City of Albuquerque Stormwater Construction Site Inspection Report

ESC File No.	H17E097	Project Name:	Carlisle Crossing		
NPDES Id. No.	NMR10040K NMR10040H	Location:	2100 Carlisle Blvd. NE		
3/30/2022	Owner	Contractor			
Operator	Carlisle Associates LP	Jaynes Corp.			
Contact name & title	Dave Rosen C/O Joe Bernabeo	Jesus Ortiz			
e-mail	jbernabeo@rosenmgmt	jesus.ortiz@jaynescorp.com			
Contact Phone #	505-304-4516	505-345-8591			
COA Inspector	Doug Hughes	Start/End Time:	9am		
Construction Phase:	Excavation/grading				
Type of Inspection:	<input type="checkbox"/> Regular	<input type="checkbox"/> Storm Event	<input type="checkbox"/> Past Storm Event >0.25"	<input type="checkbox"/> 311/Complaint	<input checked="" type="checkbox"/> Follow Up
Weather at time of inspection?		Cloudy	Temperature: ~		55
Estimated date of last storm 0.25" or greater		3/23/2022

TEMPORARY EROSION AND SEDIMENT CONTROL PLAN

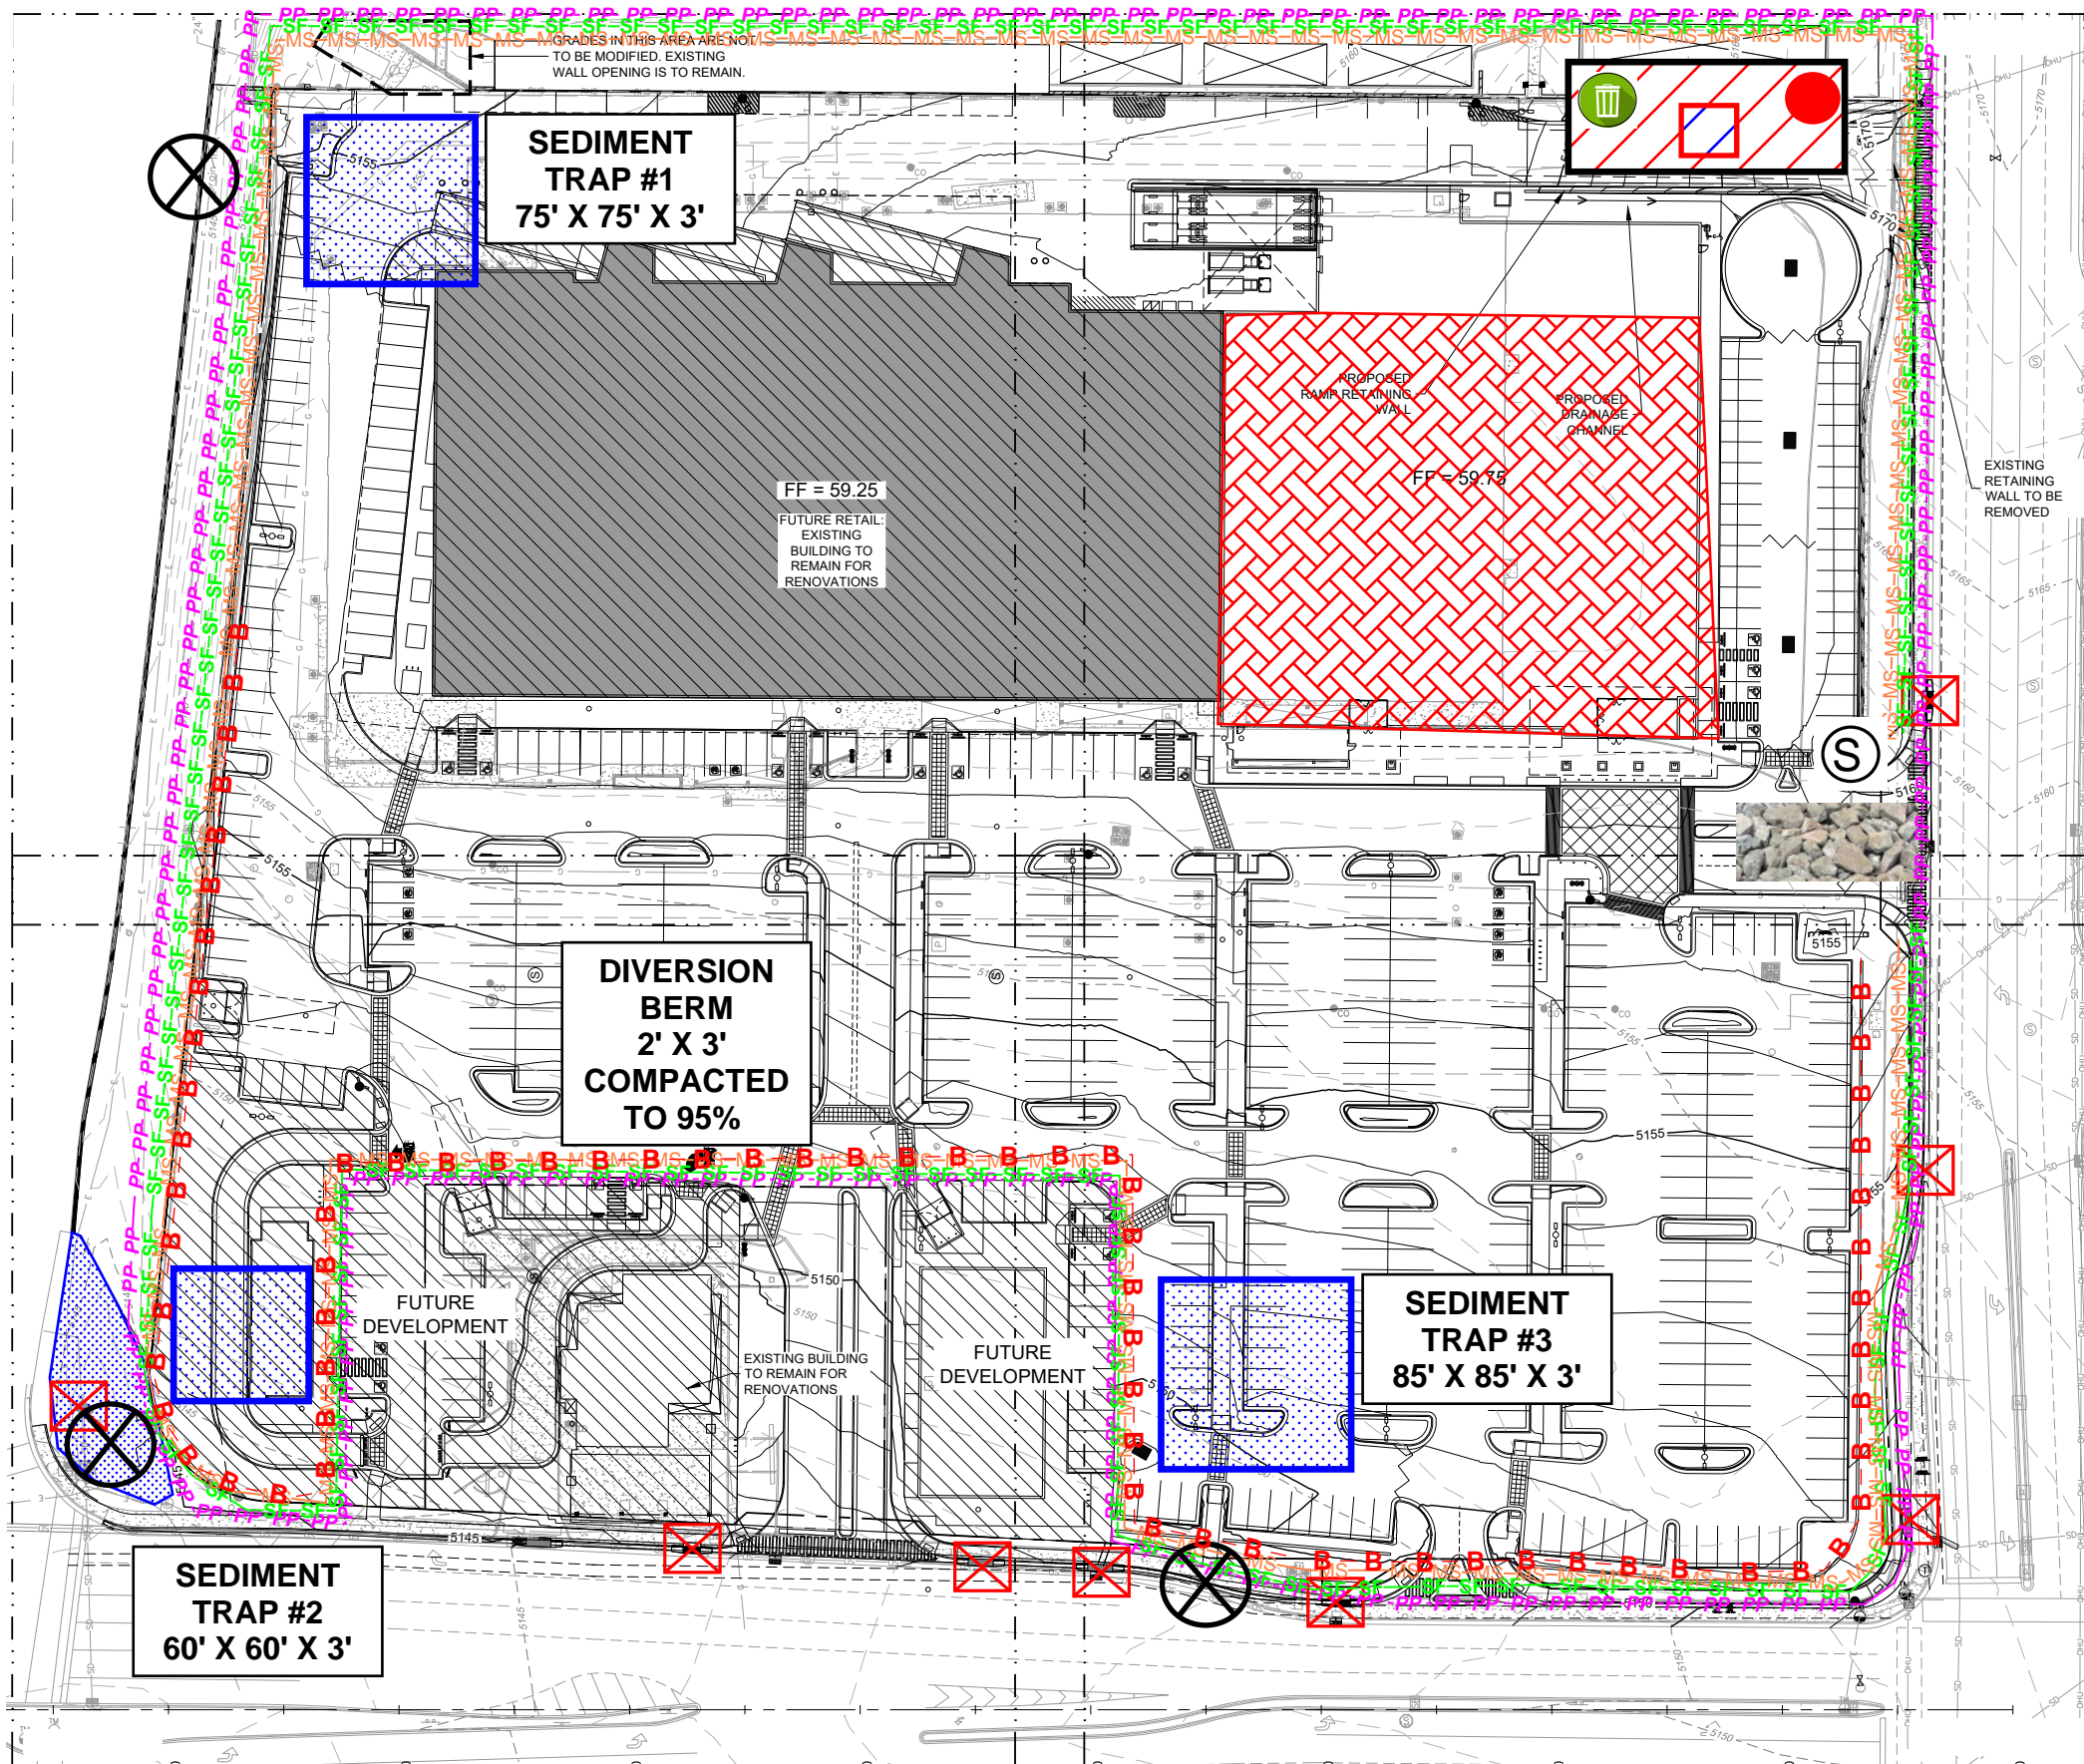
Item Number	Deficiency/ Corrective Action				
1	The sediment trap in the northeast corner is smaller than the ESC Plan calls for. Since the east side and outfall are due to be paved in only three weeks, and since drainage to that corner has been negligible during the three rain events that exceeded 0.25' this year, we will monitor the BMP for a short time. Base course is scheduled in the NE corner next week, and it is to be paved within the next 3 weeks.				
2	The SWPPP map doesn't reflect current conditions and must be updated.				
	Note that the material being used a base course doesn't have enough big rock to accomplish stabilized ground cover and the rock content is too inconsistent leaving large areas with no rock at all. All disturbed areas not paved in three weeks will be protected by silt fence or stabilized with gravel.
